**RE: Response to City Staff Review Comments  
Preliminary Site Plan Application  
Hotel Redevelopment  
1210 Brighton Avenue  
Portland, Maine**

**Planning Comments Provided by City of Portland:**

Drawing file: plans / L1.1 Landscape & Lighting Plan.pdf

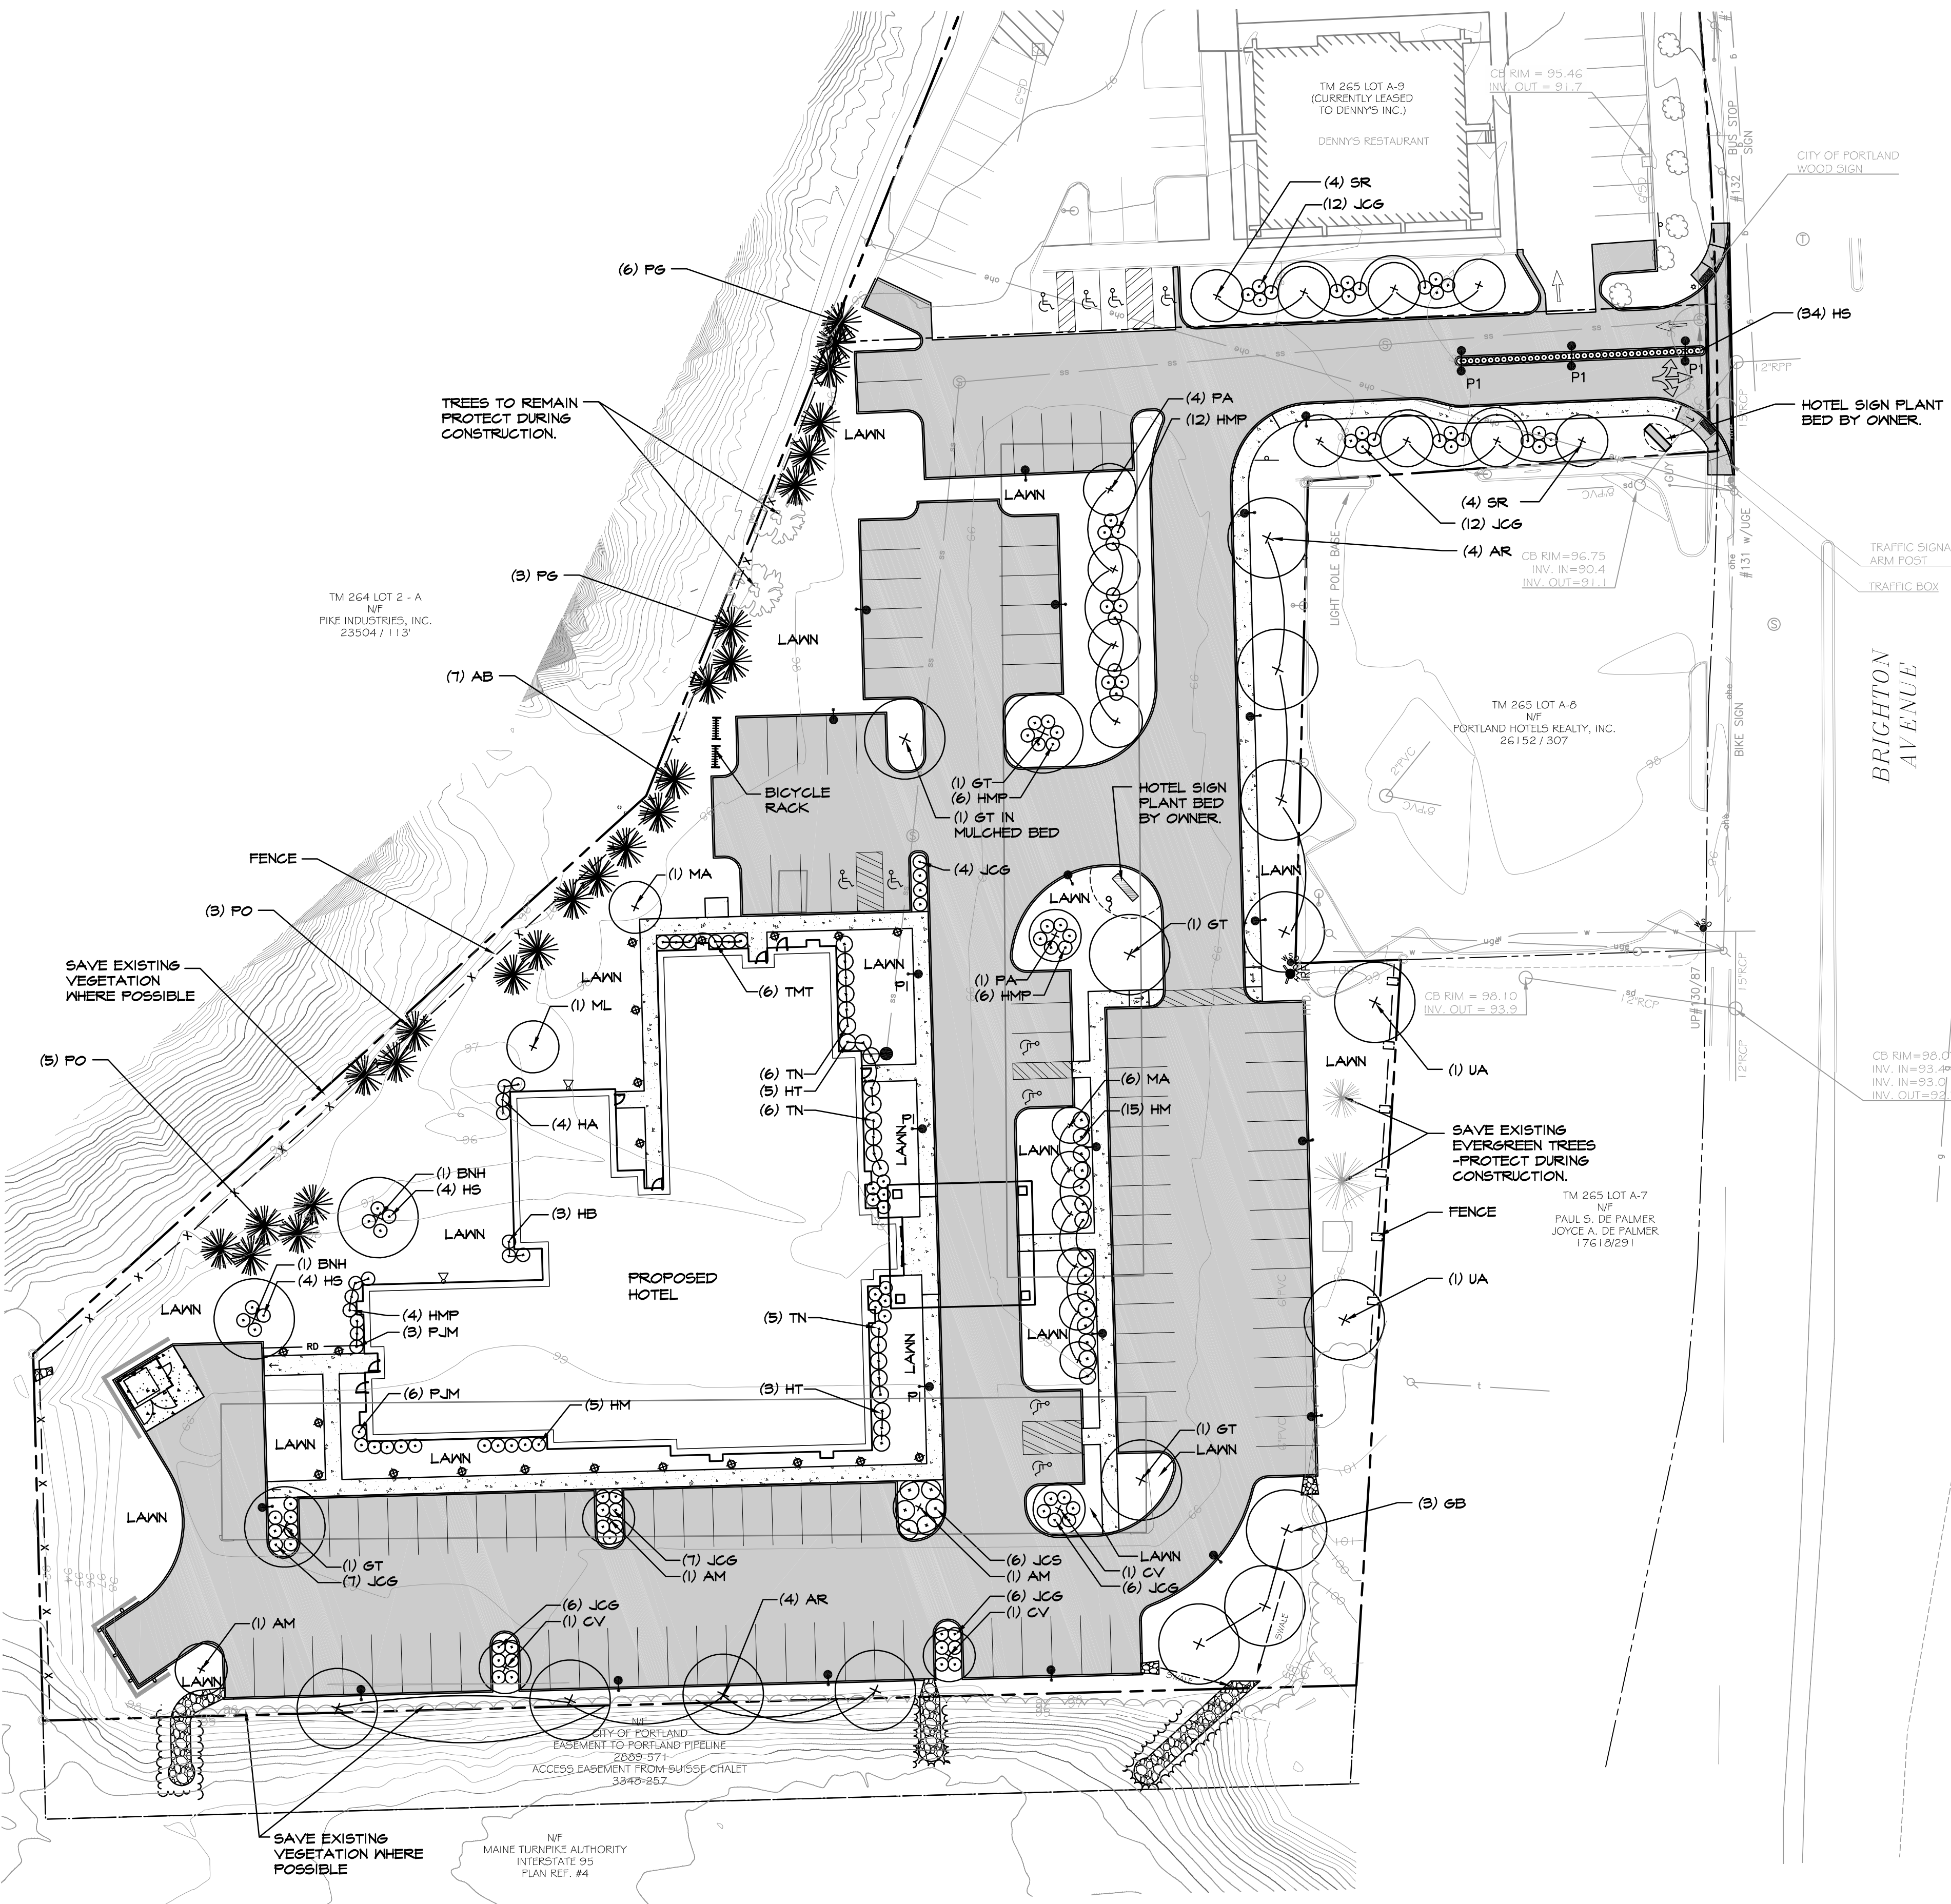
6. Please consider preserving more of the mature maples, as well as the existing evergreen trees at the front of the site.

7. Please confirm that the landscaping plan meets the understory planting requirement of 6 shrubs/45 LF of frontage (14-526(b)2b(i)(b)).

11. Please provide lighting specifications and a photometric plan in the revised submittal.

1. Parking lot area tree / landscape should meet city standards in regards to planting volume per parking space count per note. Portions of the parking lot on the Brighton Avenue side and the small lot towards Denny's appears to be low or could be better served. Shade tree density should be closer to 35' - 40' on center.

2. Tree species should not include: Canadian Hemlock due to Hemlock Woolly Adelgid outbreak in Portland, Colorado Blue Spruce due to insect & disease issues, Linden due to issues with sap dripping on cars, and no Callery Pears due to storm damage frequency. Shrubs on the not recommended list includes invasive types such as Euonymus/Burning Bush. We can supply list of recommended plant types or help refine the proposed list.

3. Tree sizes for shade trees should be 2.5" caliper minimum per city standards. Evergreen trees should be 5-6' minimum height.

4. Project view from Brighton Avenue should be improved screening with increased tree / landscape buffer between proposed hotel and existing lots fronting on Brighton Avenue. This should include a low solid wood fencing or black vinyl chain link 5' minimum height. The proposed entrance drive and the shared space with Denny's should be defined and approved with landscape treatment to the extent possible to better define entrance.

5. Existing tree save - existing trees along the project edge including Maine Turnpike & Pike Industries should be saved & protected during project construction. Tree-save measures should be included in final plan.

*We have made efforts to preserve the existing trees to the extent practical including two maples on the south side of the property and the two existing evergreen trees on the north side of the property.*

*The site has approximately 171.3 LF of frontage along Brighton Avenue. This equates to a City requirement of  $171.3/45=3.8 \times 6=22.8$  or 23 shrubs, which have been located on the project site in addition to the required parking area planting. This calculation has been added to the landscape plan.*

*Light pole locations and pole heights have been added to the Landscape and Lighting Plan. As we are still in the preliminary design phase specific light poles and fixtures have not been selected yet; however, all light fixtures will be LED and full cutoff. We will provide a photometric plan with the Final Plan submission.*

*Per city of Portland standards the shade tree spacing has been adjusted to 40' on center. The site contains 113 parking spaces requiring 46 shade trees or 23 shade trees and 69 shrubs. We are proposing 28 shade trees and 95 shrubs.*

*Trees species contained in the plant list have been revised not to include the species mentioned above.*

*Tree size shown on the plant list for major shade trees has been revised per City standards to 2.5" caliper, and evergreen tree height has been revised to 5'-8'.*

*The project's Brighton Avenue side has been improved with a section of large deciduous shade trees planted 40' o.c., the preservation of two evergreen trees and a section of fence. Shrub plantings have been added to the east side of the entrance drive. The west side of the entrance drive (Denny's) is existing parking leaving no space for plantings.*

*No trees will be removed on the side of the property adjacent to the Maine Turnpike. Only brush will be removed for the installation of riprap swales and plunge pools on the slope. We have saved as many trees as possible on the Pike Industries side of the property. Two additional mature evergreen trees will be saved on the front of the property.*
